18 December 2015

CBD and South East Light Rail Project – Submission to the EIS

The University of NSW supports the Light Rail Project. UNSW's Kensington Campus is forecast to be the largest single customer destination with two light rail stops. UNSW's submission is supported by external traffic, safety, planning, design and utilities advice.

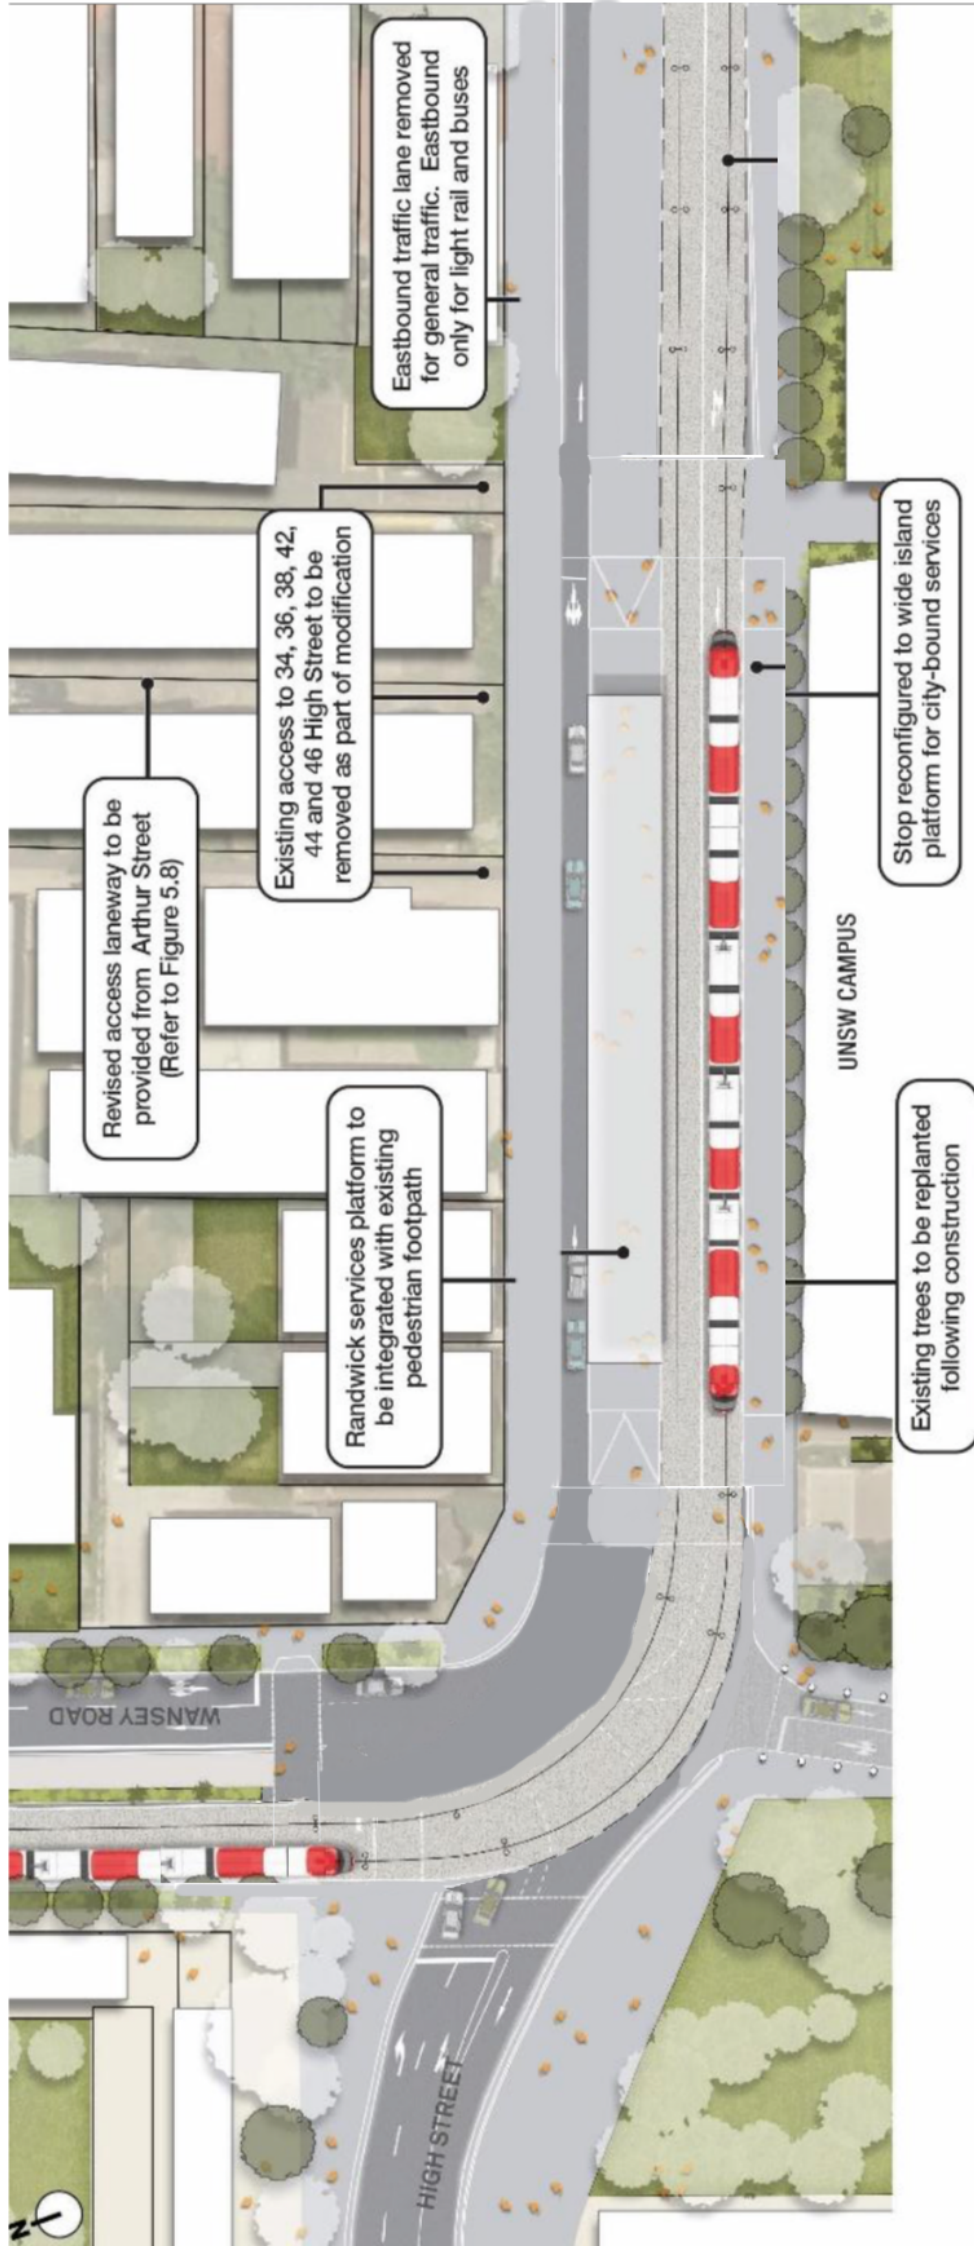
- 2) Lack of consultation and process:
 - a. As the landowner UNSW, was unaware of the extent of the land take for the hammerhead in the Arthur Street laneway until receiving the modification report. The hammerhead is not required because garbage trucks do not access private properties in the Randwick City Council area. This was advised to TfNSW at a meeting with UNSW and Randwick City Council.
